DECISION DELEGATED TO HEAD OF PLANNING

Application No: H06-1292-25 **Applicant:** Mrs K Doubleday-Collishaw

Proposal: Erection of Agricultural Dwelling - outline approval H06-0101-24

Location: Land At Green Lane Holbech St Johns Spalding

Site Plan
Scale: 1:200

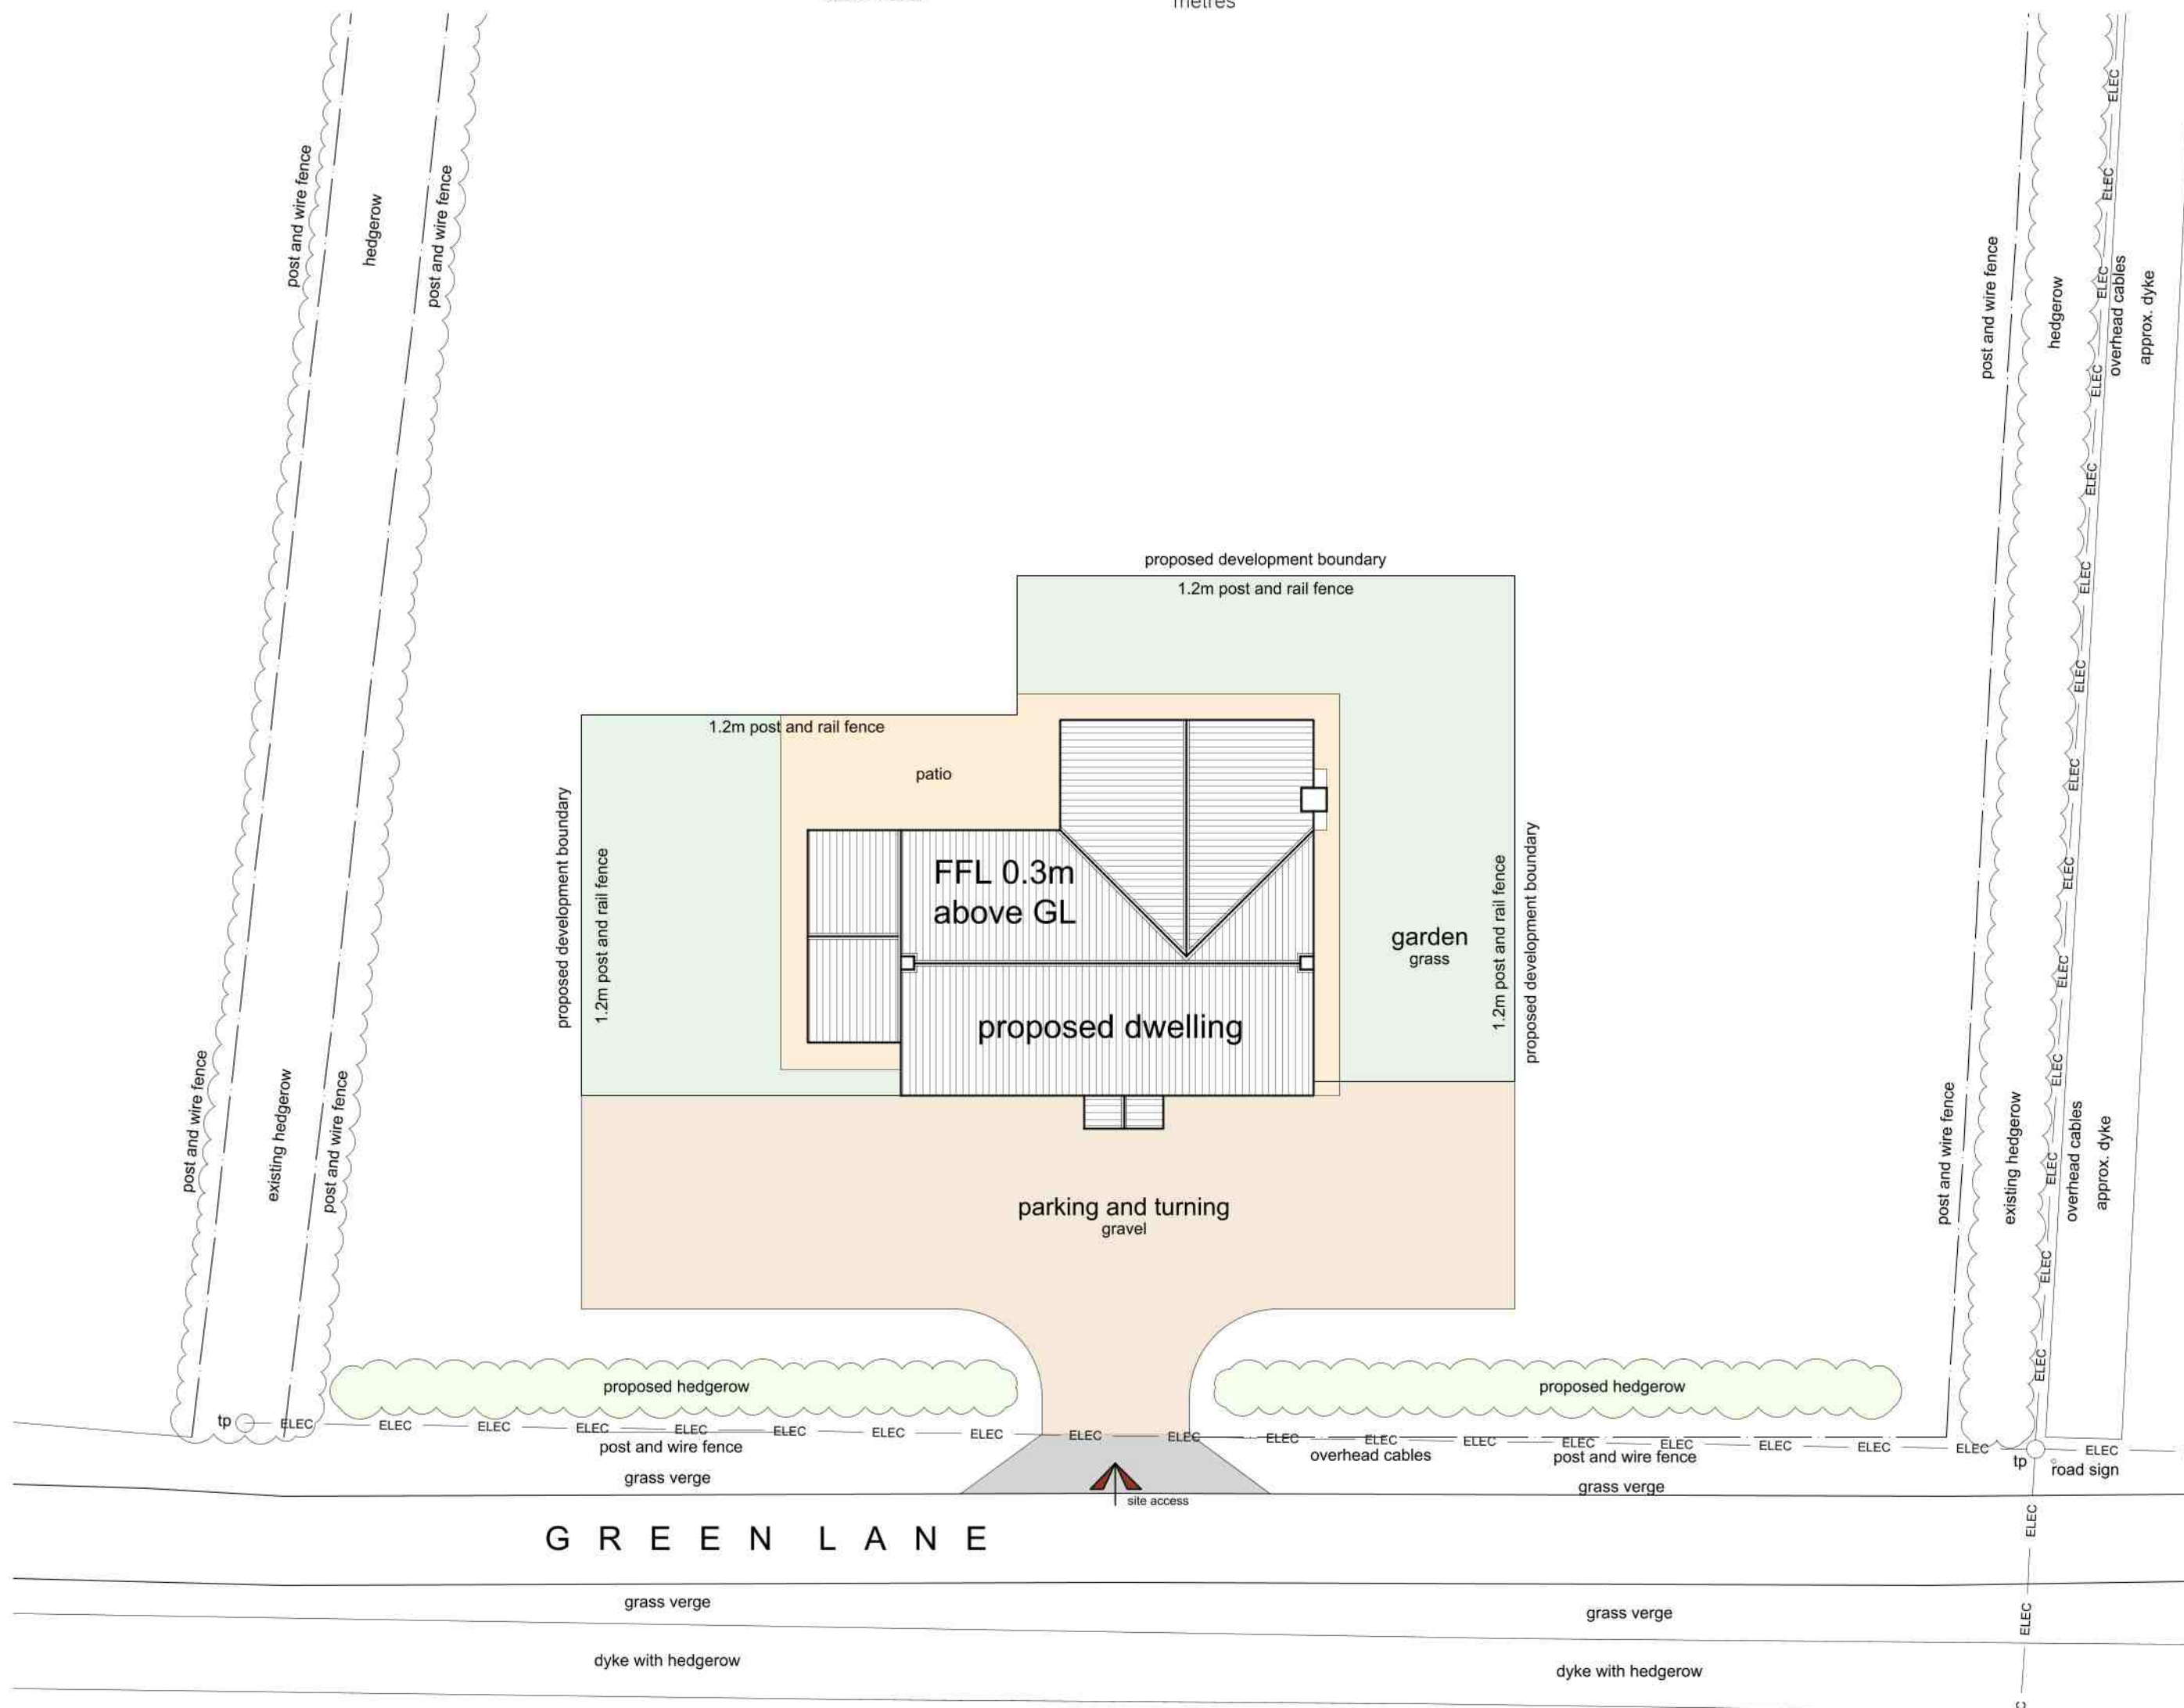
Initially proposed was a garage and car port to the front of the plot on the left hand side of the driveway. These were removed following concerns in respect of their impact on the street scene.

A note needs to be added to the proposed site plan to say that the access will be constructed to Lincolnshire County Council Specification.

A vehicular access is proposed from Green Lane. The proposal provides for adequate parking and turning. Lincolnshire County Council (as Highway Authority) have asked for a note to be made on the site plan to say that the access will be constructed to Lincolnshire County Council Specification. This has not been done so a condition is to be included on the decision notice.
